Re: Mirehaven Arroyo A Improvements LOMR Request (Case No. 18-06-0625P)
FEMA Comment Response Letter
FEMA Case No. 18-06-0625P
COA Hydrology File No. H09D017D

This letter supports the second submittal to FEMA of the Letter of Map Revision (LOMR) Request package for the case number referenced above located within the City of Albuquerque and Unincorporated Areas of Bernalillo County, New Mexico. The request has been revised to address your request for additional data, dated February 1, 2018, and in accordance with our phone call on February 28, 2018.

**NATIONAL FLOOD INSURANCE PROGRAM**  
FLOOD INSURANCE RATE MAP  
BERNALILLO COUNTY, NEW MEXICO  
and Incorporated Areas  
PANEL 307 OF 825

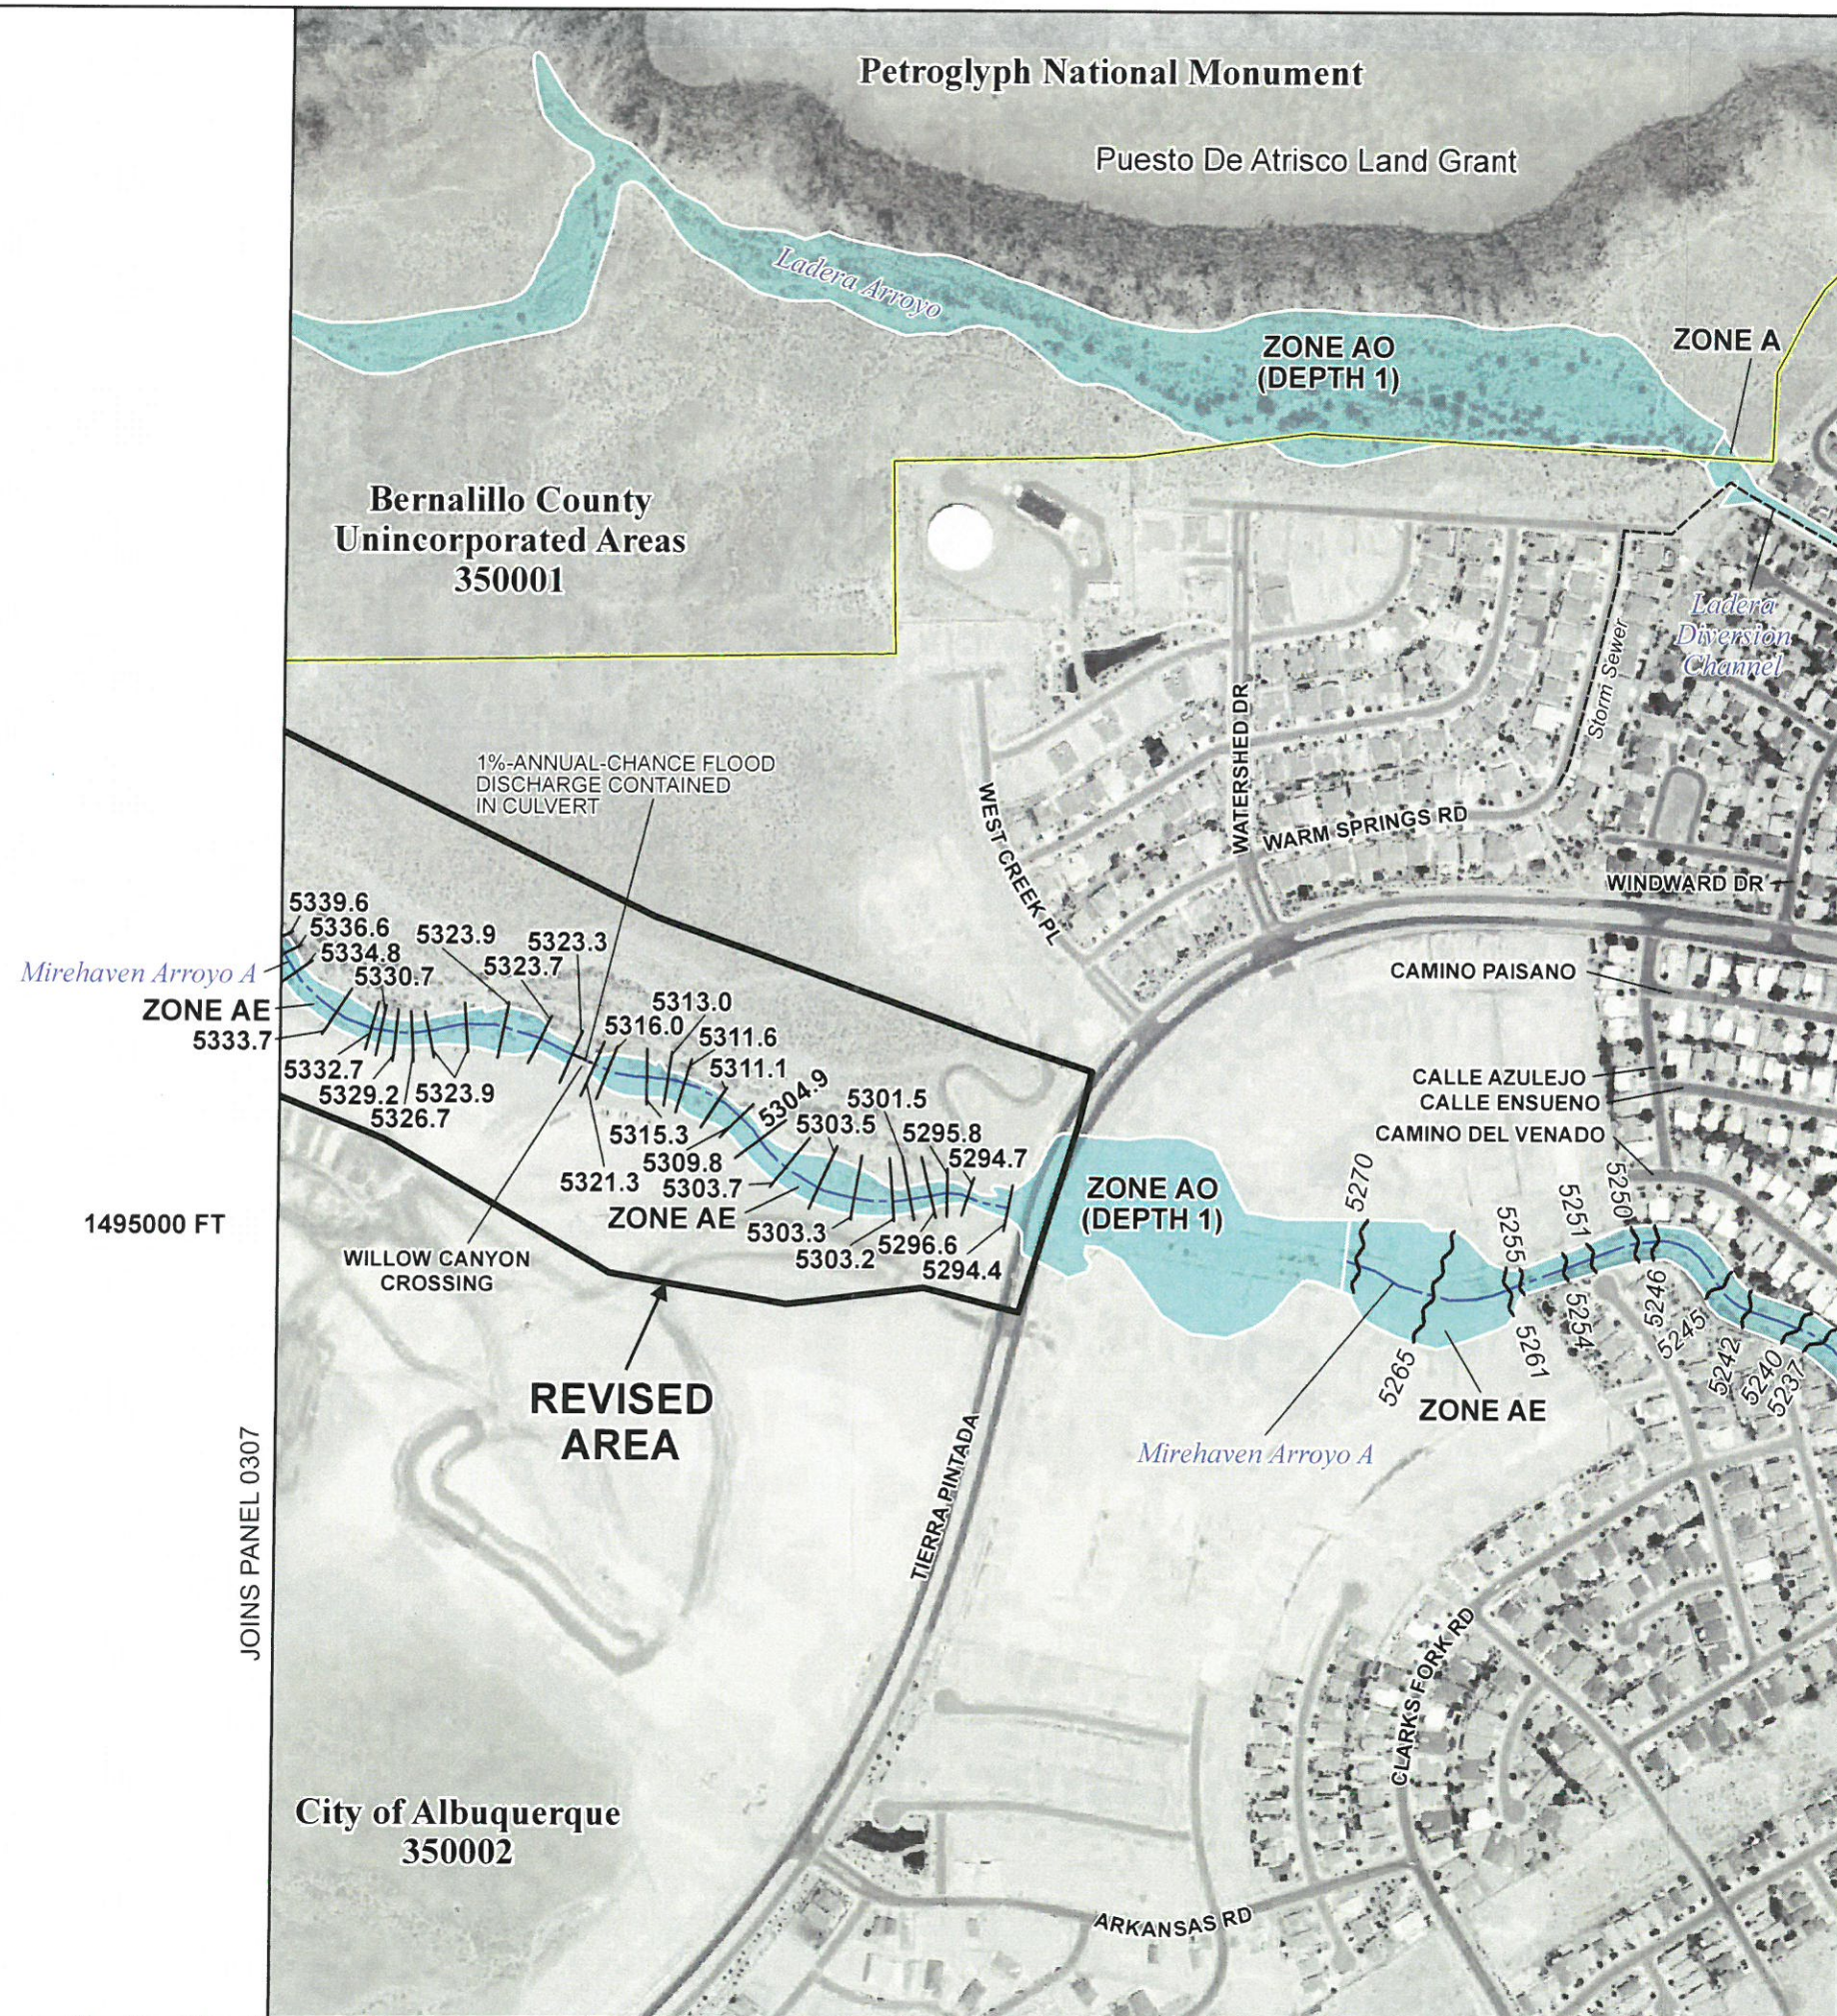
3. Our review revealed that the HEC-RAS levee option was used in the submitted post-project conditions hydraulic analysis at Cross Section 6484. Please remove the levee option if the right channel bank is not acting as a levee. If it is acting as a levee please show that it meets the requirements of Section 65.10 of the National Flood Insurance Program (NFIP) regulations, and complete the portion of Application/Certification Form 3, entitled "Riverine Structures Form," relating to berms for this project. Please note that an additional fee is required to process a LOMR that involves a berm/floodwall/levee system.

4. The following comments are based on our review of the post-project conditions hydraulic analysis and the submitted topographic work map entitled "Mirehaven Arroyo A Improvements LOMR, Figure 2-Topographic Workmap," prepared by Bohannon Huston, Inc., dated November 10, 2017. Please provide an explanation for these discrepancies, or make the appropriate changes and submit a revised work map that is certified by a registered Professional Engineer (P.E.).

- a. The revised delineation does not tie-in with the effective delineation at the downstream end at Cross Section 1606.
 - *Response: As discussed in our February 28, 2018, phone call, we have provided a graphical tie-in of the revised SFHA limit to the effective SFHA limit.*

- b. The stream centerline is outside the base floodplain at Cross Section 6484.
 - *Response: The stream centerline has been revised to follow the arroyo low flow channel at that location and is now within the base floodplain.*

- *Response: The levee option has been removed from the referenced HEC-RAS cross-section as it was only used to prevent flow from showing in the hydraulically isolated Mirehaven Arroyo A tributary from the north. The cross-section has been shortened to exclude that tributary, which produces the same model results. The shortened cross-section is reflected on Figure 2-Topographic Work Map.*
